Issue Specific Hearing 2

Thursday 1 December 2022

Supplementary Agenda Additional Questions

Drawing file: TR010062 / TR010062-000549-5.19 Rights of Way and Access Plans Scheme 11 A1(M) Junction 53 Scotch Corner.pdf

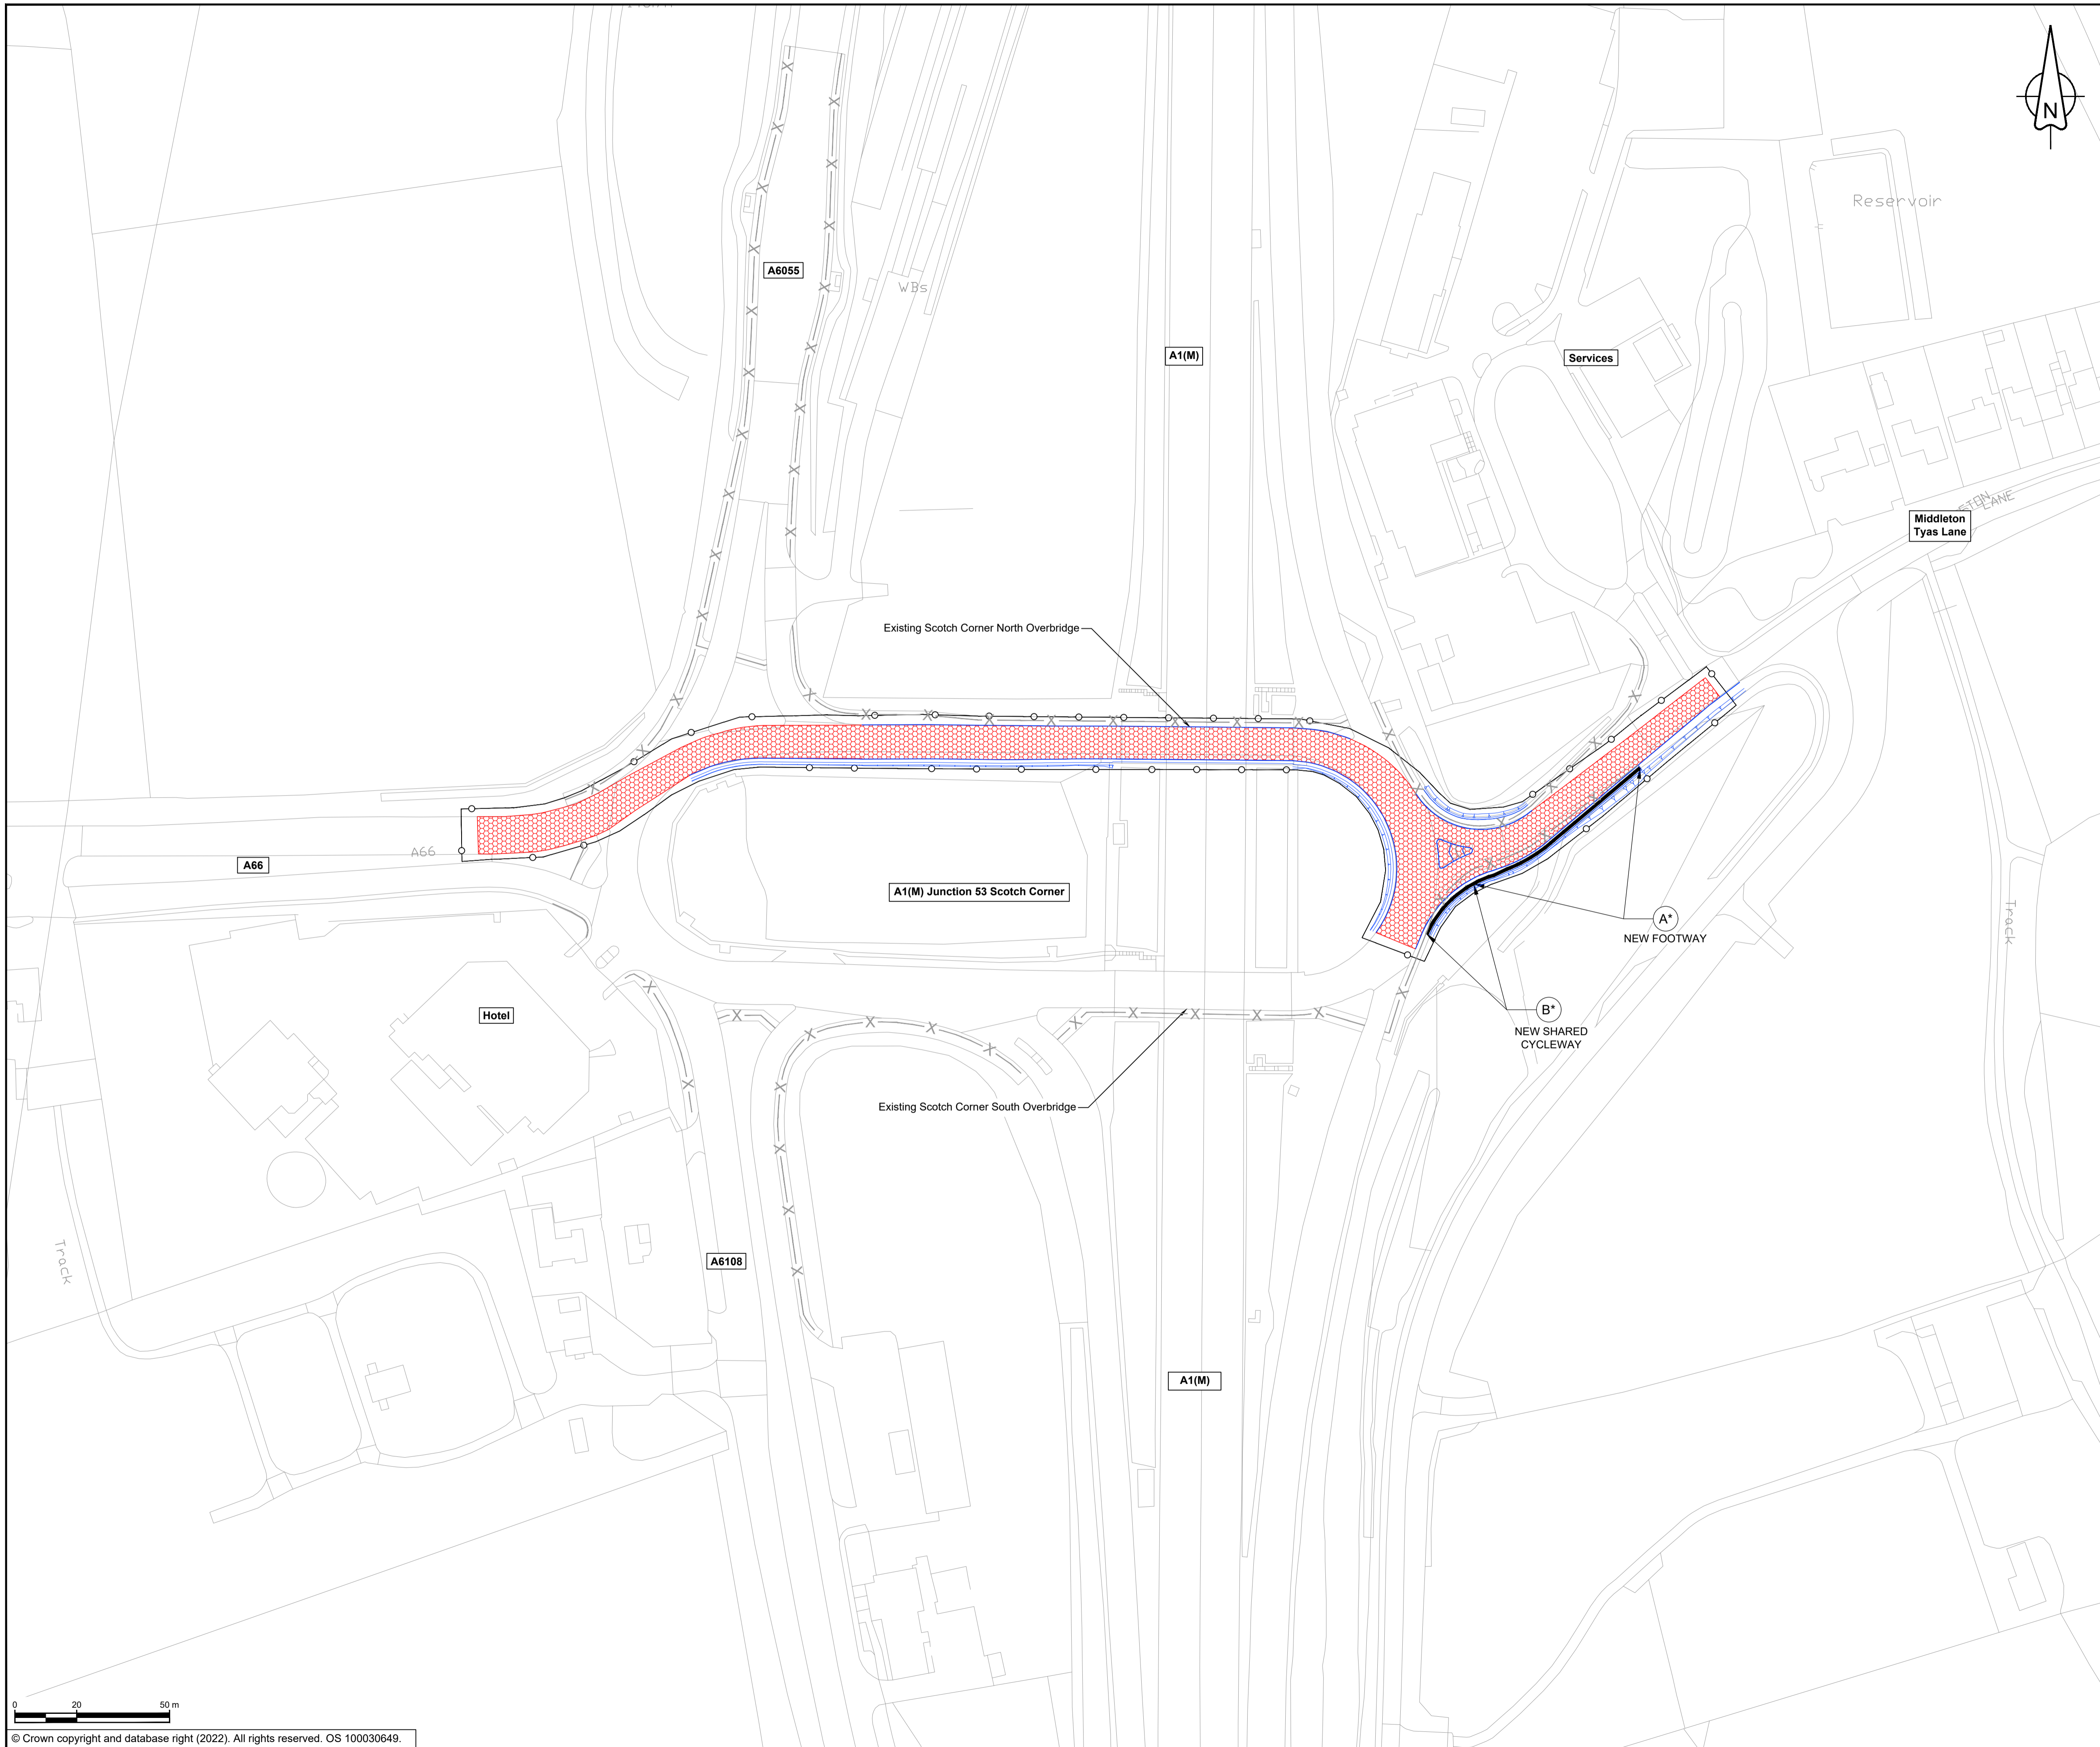
| ISH2.TT.09 | | Applicant | Table 10.14. This table records no impact on existing bus routes or stops at Scotch Corner (Scheme 11) but the General Arrangement Plan [APP-018] shows the existing bus stop being amended. This appears to be used by a service 34 from Darlington to Richmond. The works and possible disruption to the service needs to be recorded and also consideration should be given for pedestrian facilities to enable access to the services on the other side of Middleton Tyas Lane. Confirm. |
| ISH2.TT.11 | | Applicant | Paragraph 11.8.4 does not mention bus stop on Middleton Tyas Lane that will be affected by Scheme 11 works. Clarify whether this be included in consideration of CTMP. |
